CITY OF ALBUQUERQUE

January 13, 2012

**Re: Garcia's Kitchen, 8518 Indian School Rd NE, Traffic Circulation Layout
Engineer's Stamp dated 11-28-11 (J20-D008)**

TRAFFIC CIRCULATION LAYOUT
FOR
GARCIA'S KITCHEN
(8518 INDIAN SCHOOL ROAD N.E.)
ALBUQUERQUE, NEW MEXICO
OCTOBER, 2011

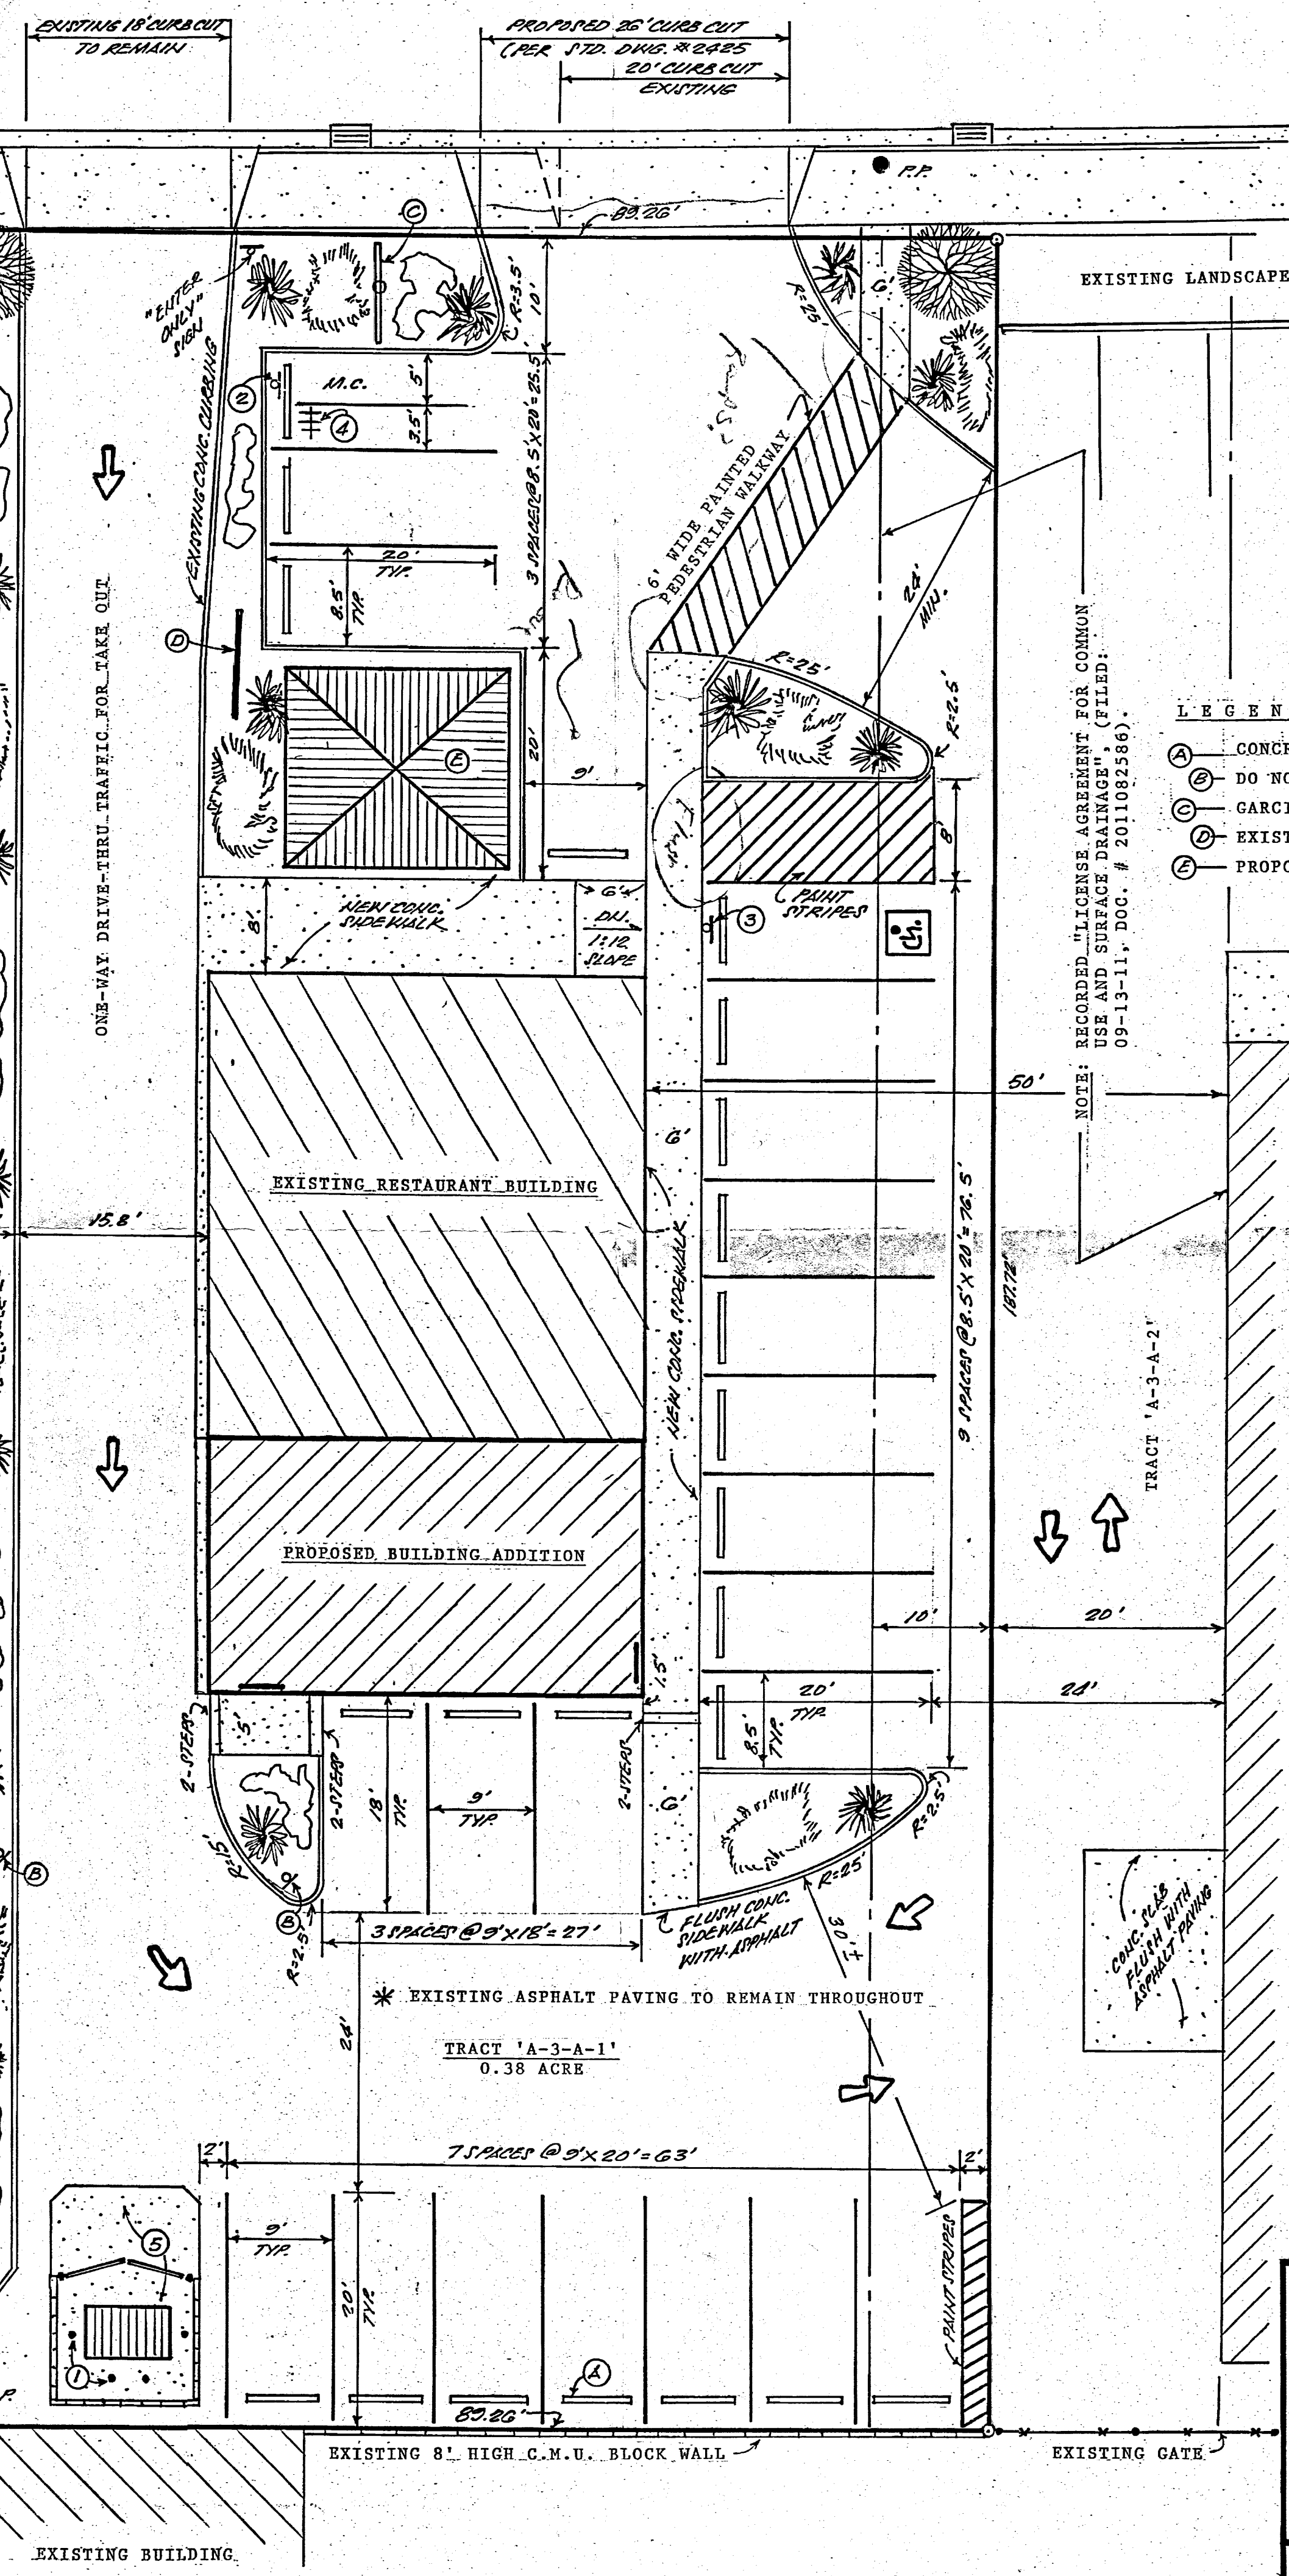
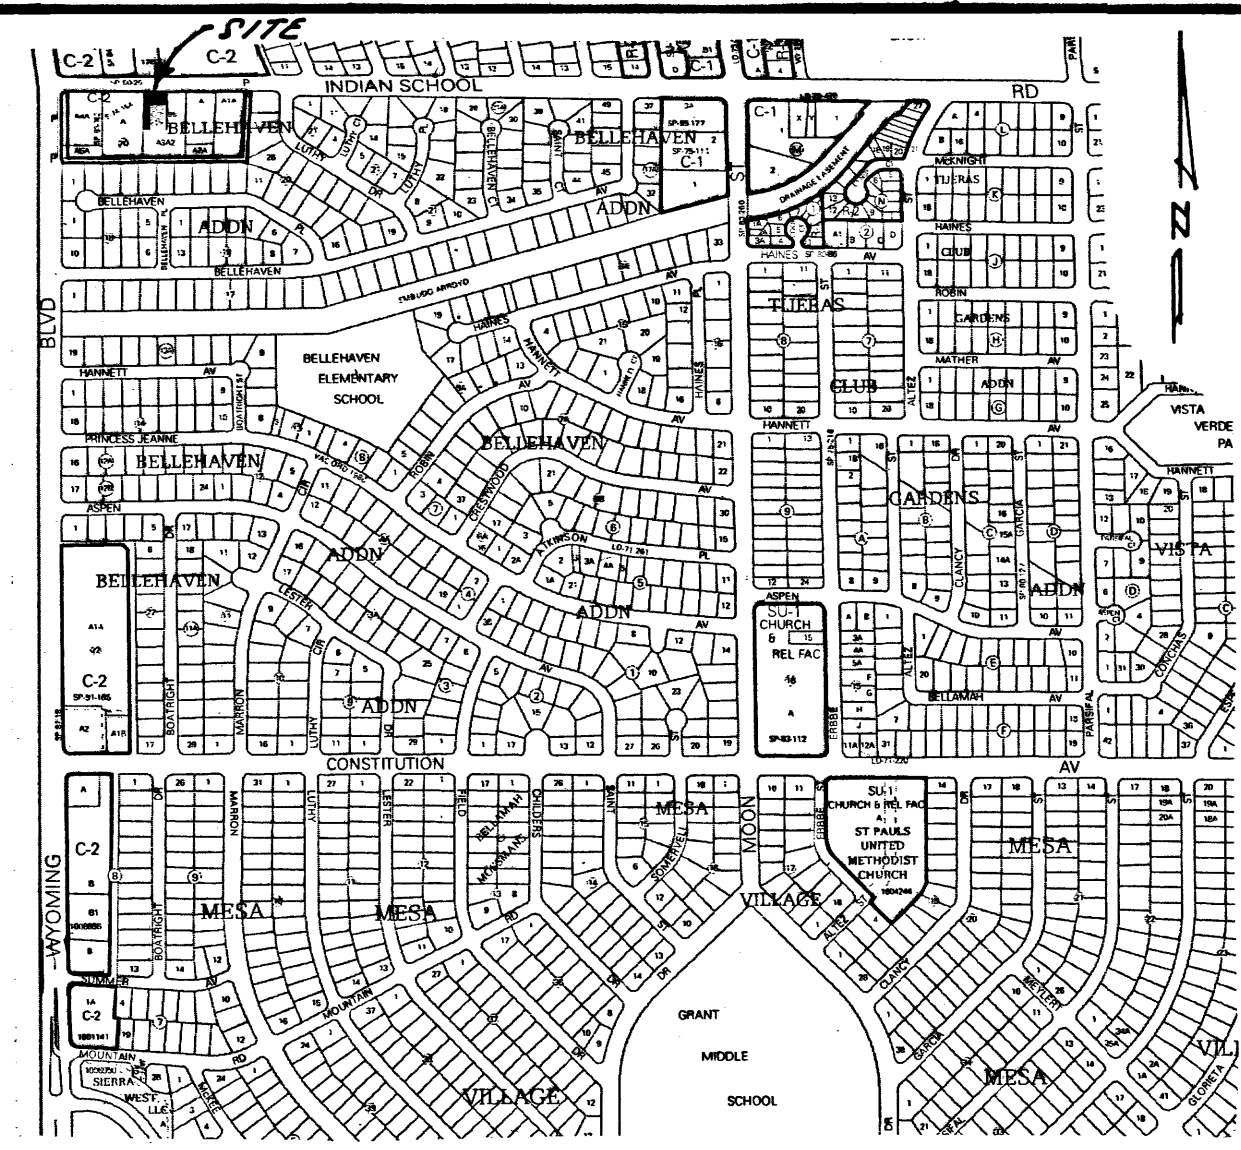
1. Clearly show the ADA accessible pathway from the public sidewalk to the building. Show all ramps or note flush elevation.
2. The parking stall located directly east of the "Canopy Patio" is not provided with adequate maneuverability to safely operate. Please remove this parking stall.
